BARNSLEY
Metropolitan Borough Council

REFUSAL OF PLANNING PERMISSION

APPLICATION NO. 2014/1466

Proposal Erection of two storey front and side extension to dwelling.
At 36 Lawrence Close, Higham, Barnsley, S75 1PE

PLANS & ELEVATIONS

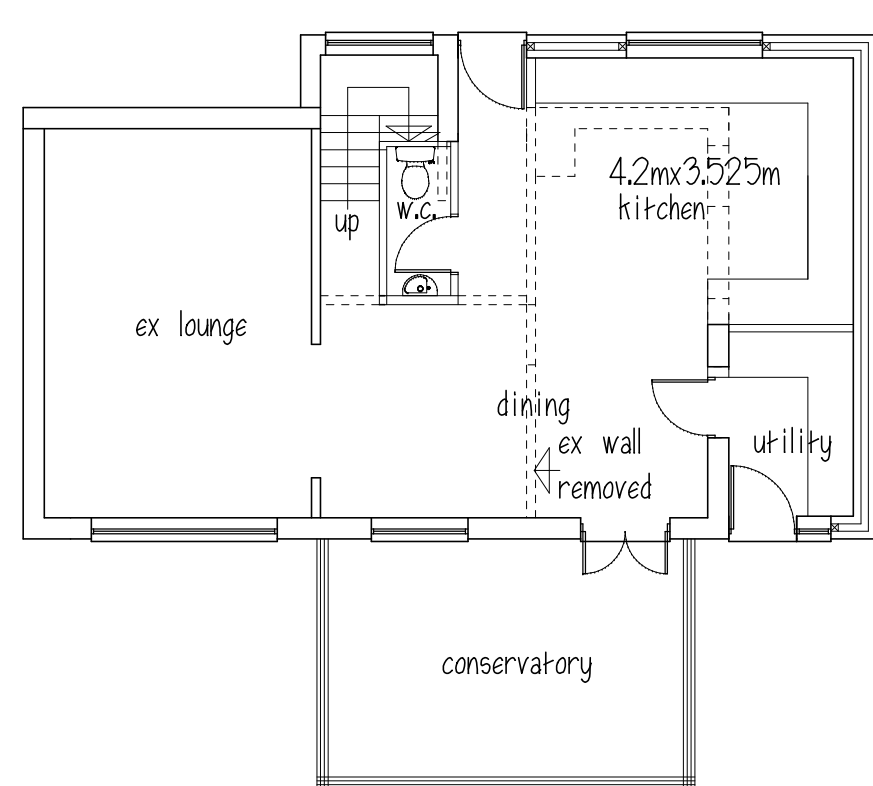
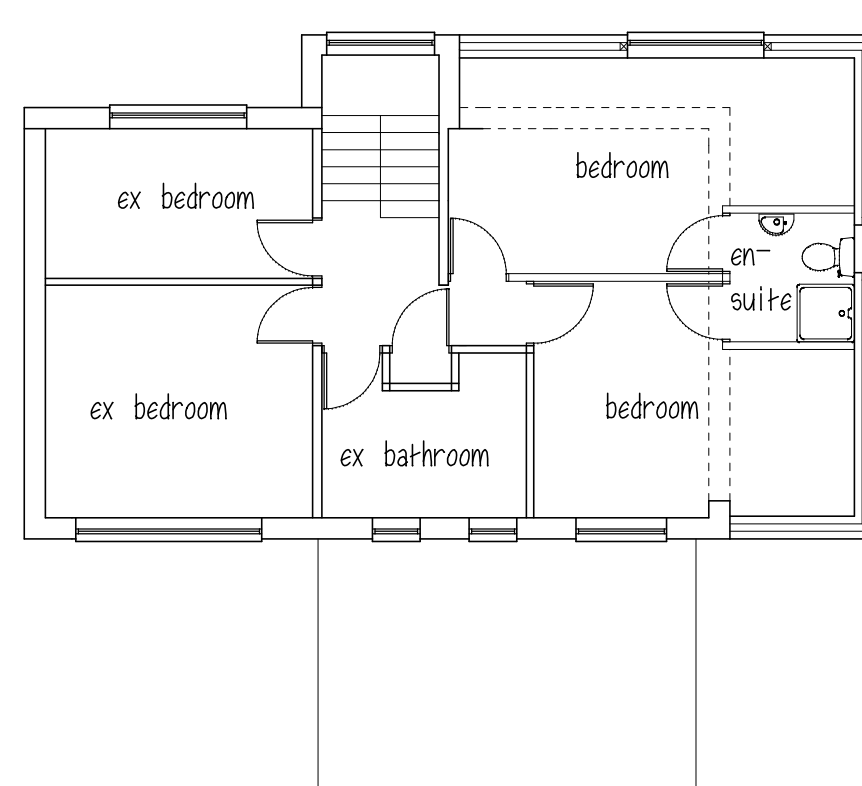
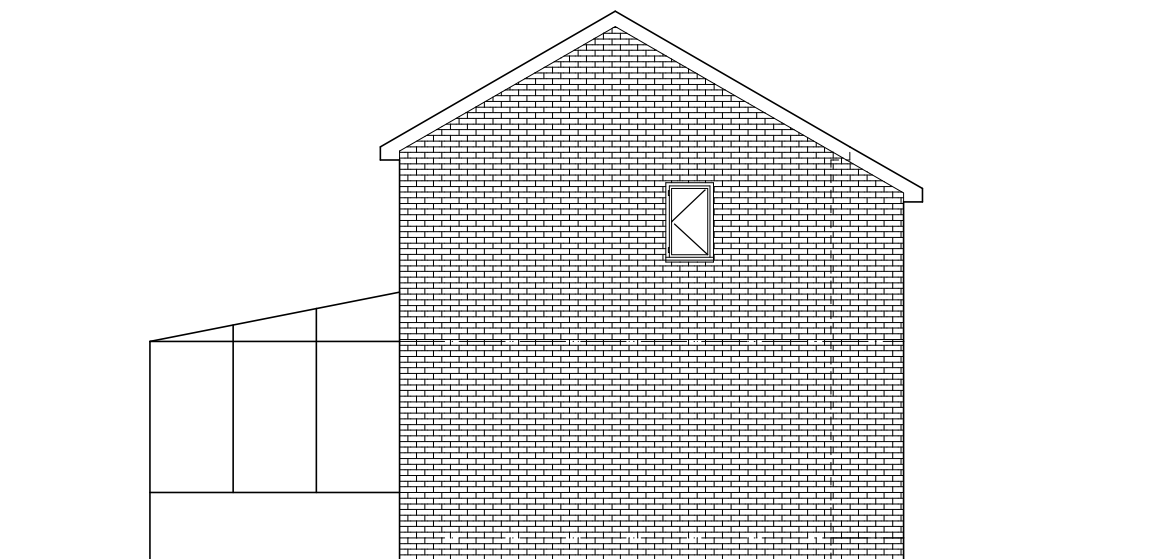
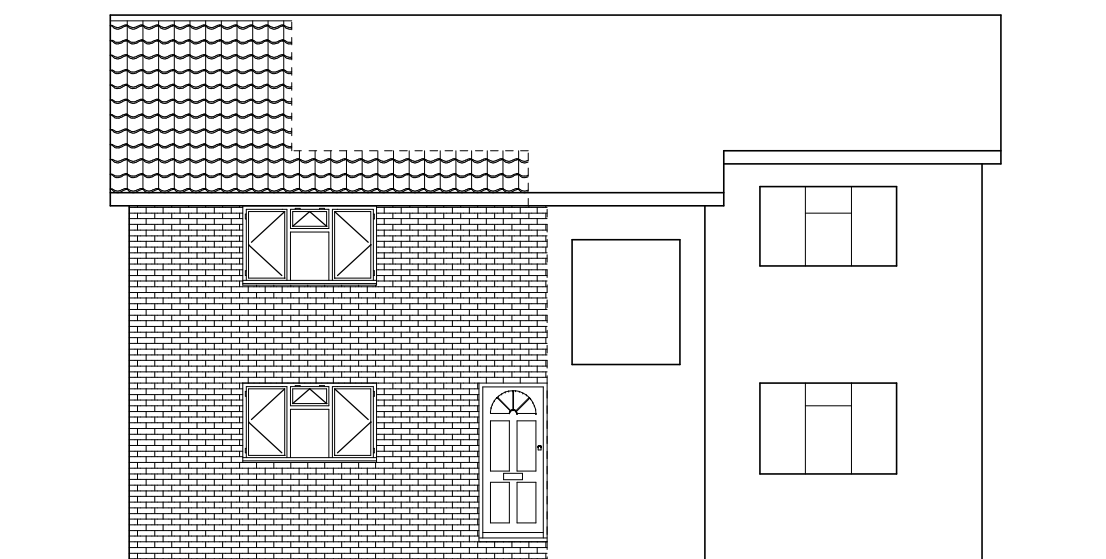
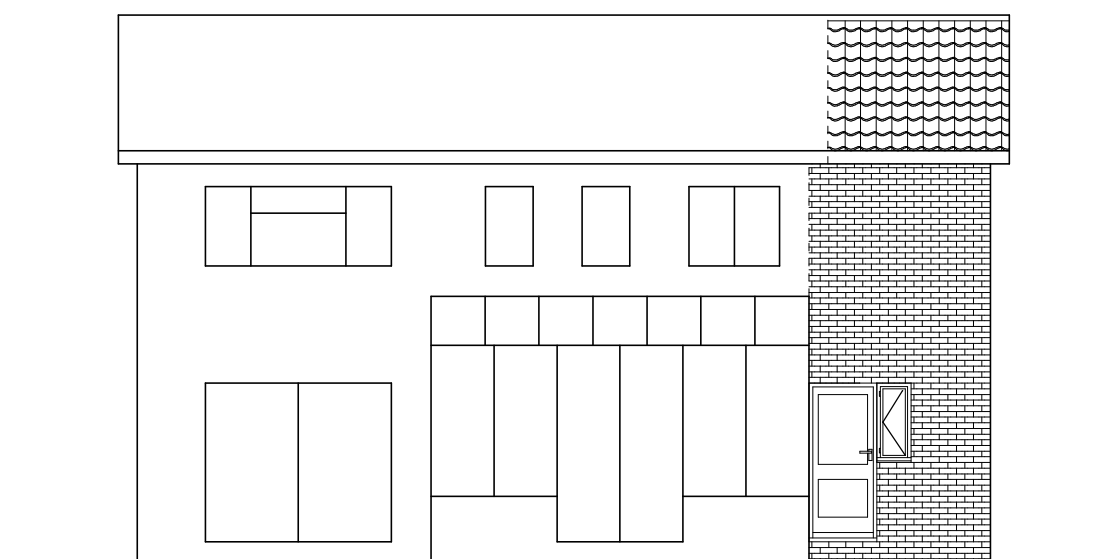
- 1 In the opinion of the Local Planning Authority, the design of the proposed extensions detracts from the quality of the existing dwelling and hence the character of the street scene. The large two storey front extension alters the character and symmetry of the original dwelling, overwhelming it in an unsympathetic manner. The two storey side extension has no set back from the principal elevation or side boundary with the adjacent property, and no lowering of the ridge line. Consequently, it is not subservient to the main dwelling and results in an unbalanced terracing effect detrimental to the quality of the property and street scene. The design of the proposed extensions therefore do not accord with CS policy CSP29, the relevant planning policy statements in the NPPF relating to requiring good design and the Council's SPD - House Extensions.
